**PAD-3**  
PADMARK BUSINESS PARK-LOT 3  
1190 MEADOWBROOK PKWY  
COLORADO SPRINGS, CO 80915  
EL PASO COUNTY, COLORADO

# Markup Summary

dsdkendall (2)

ADA EXHIBIT

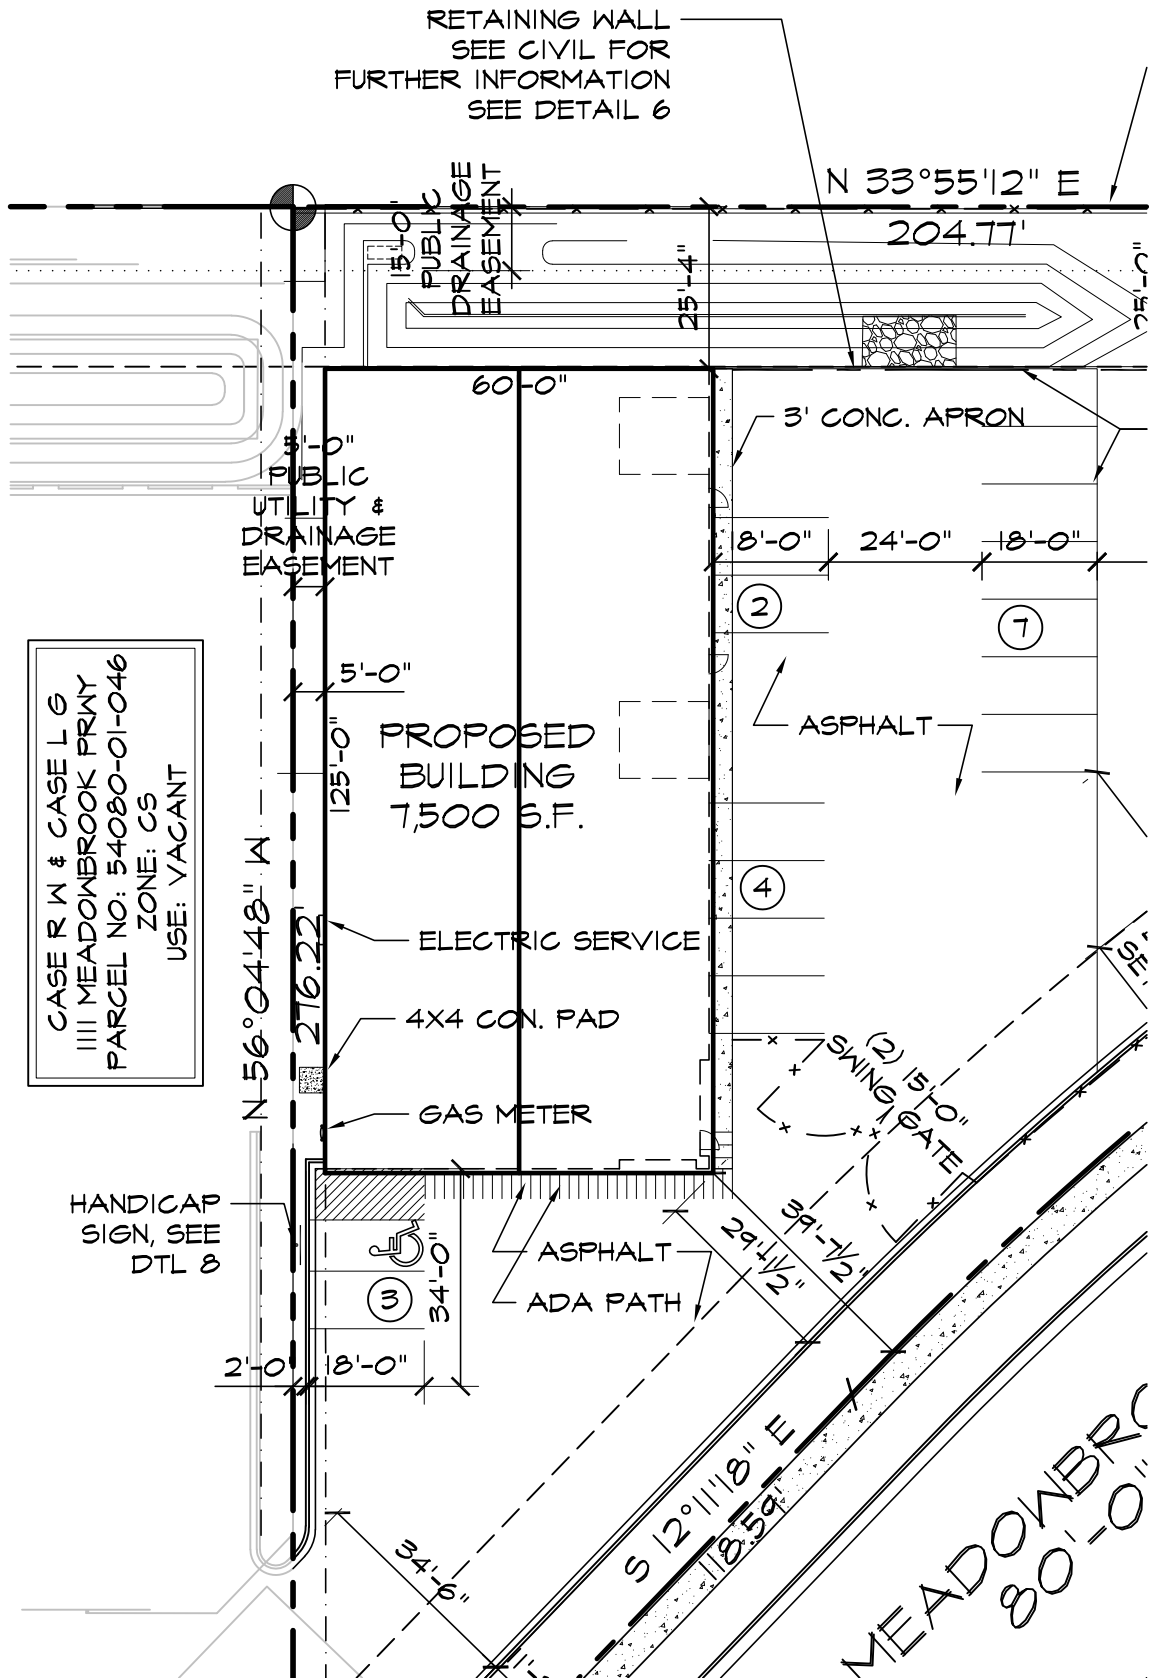
Show ADA Route to structure.
